Our Ref: AB/73/18/PL

**Town & Country Planning Act 1990 (as amended)
Town and Country Planning (Development Management Procedure) (England) Order 2015
Application for Planning Permission**

Development	Demolition of garage & erection of two dwellings with associated car parking and landscaping
Location	18 Queens Lane Arundel

EXISTING SITE PLAN
SCALE 1:500

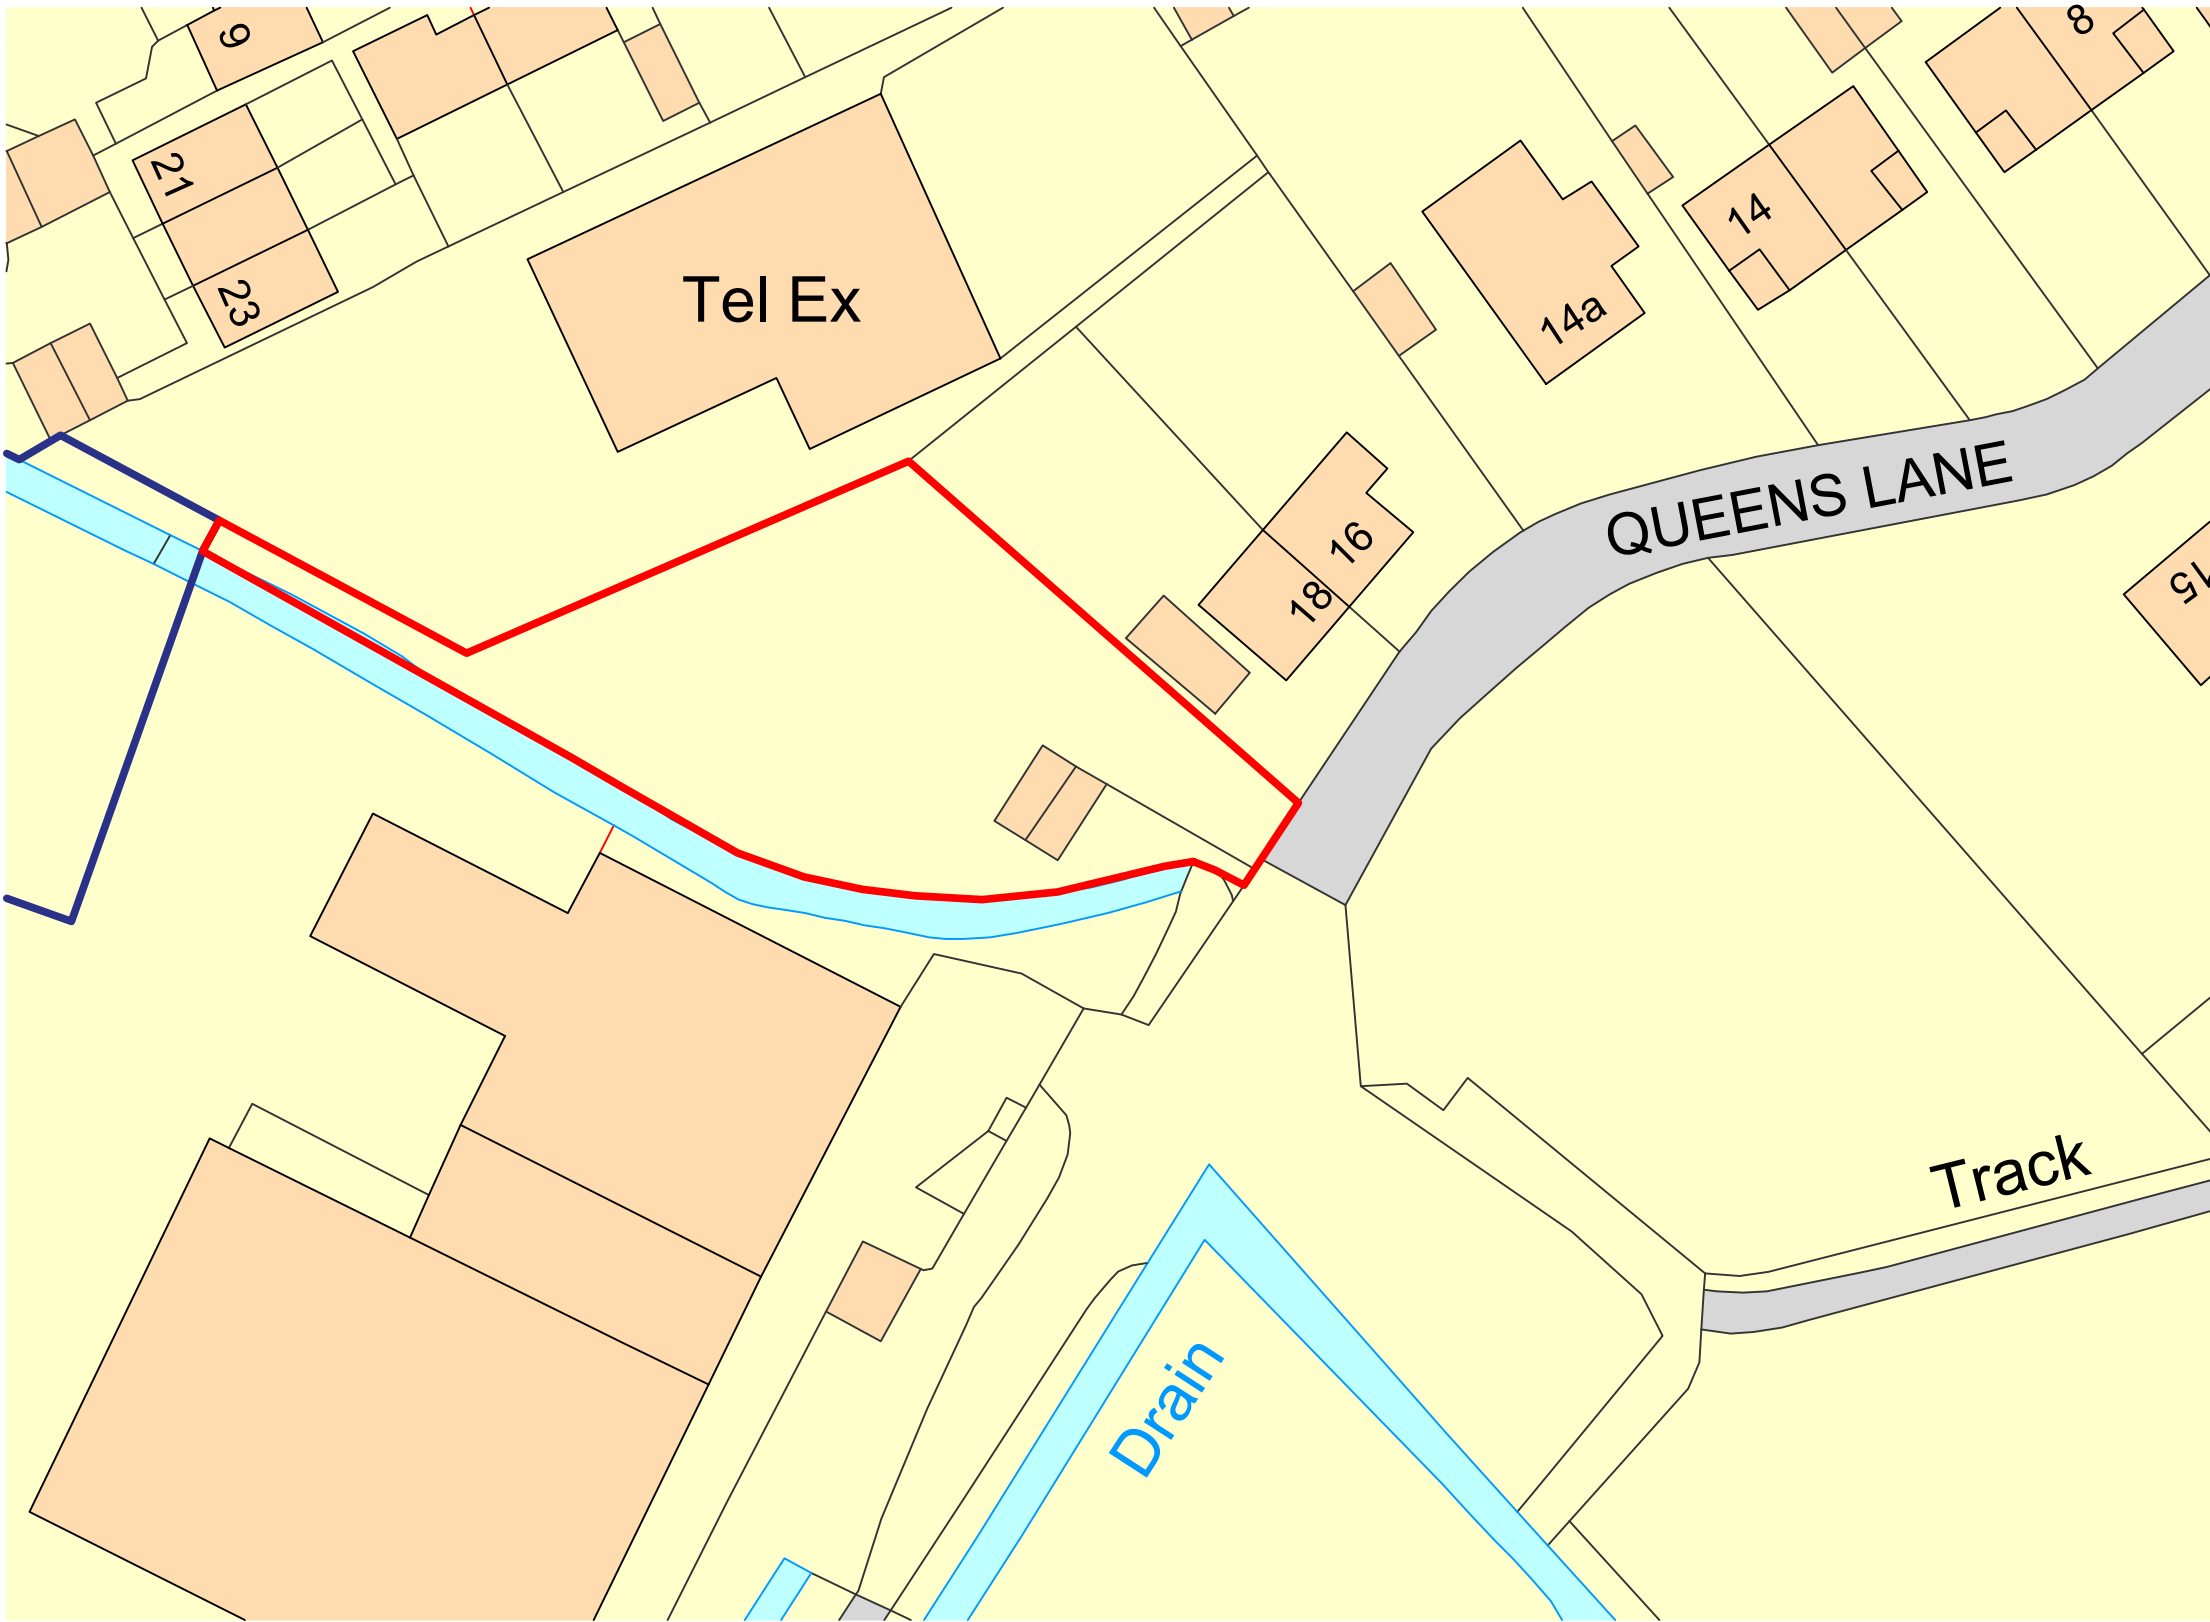
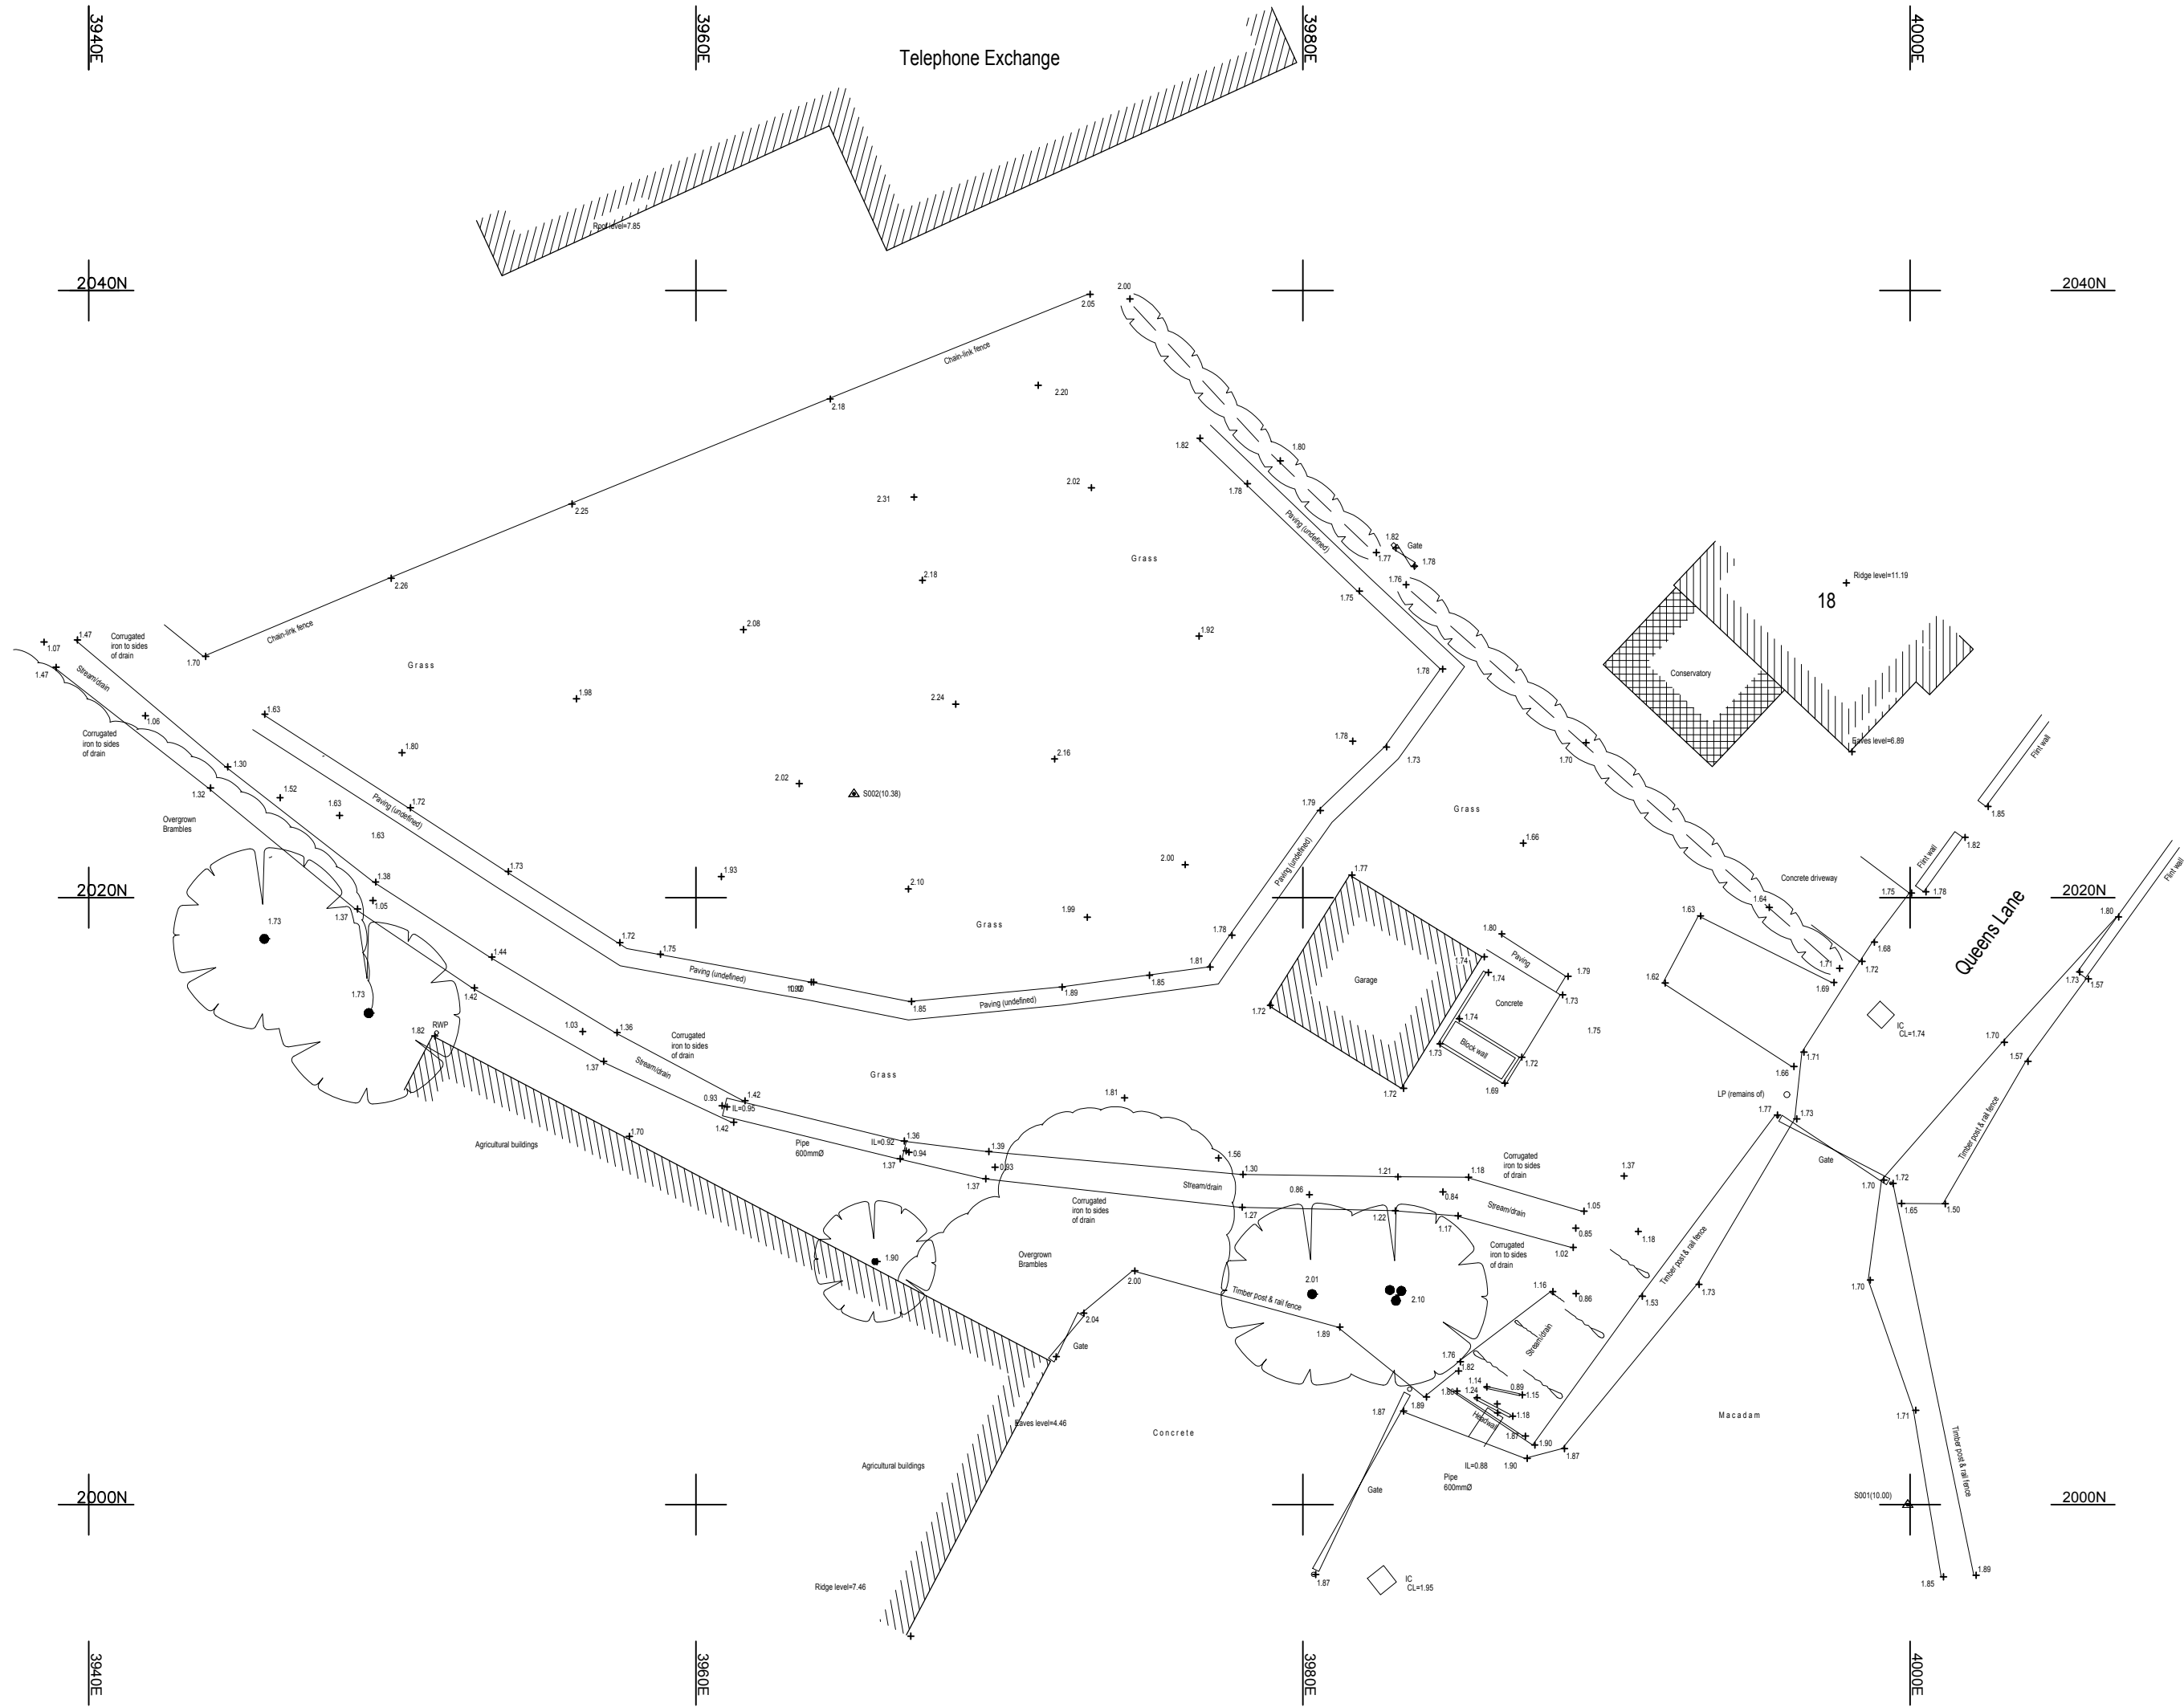
Block Plan - revised

Please submit 1 electronic or 3 paper copies of a revised block/site plan at a scale of 1:500 or 1:200 with the site dimensions clearly indicated from the proposal to the site boundaries. Further details of what must be included on the plan can be found in the National Validation Requirements.
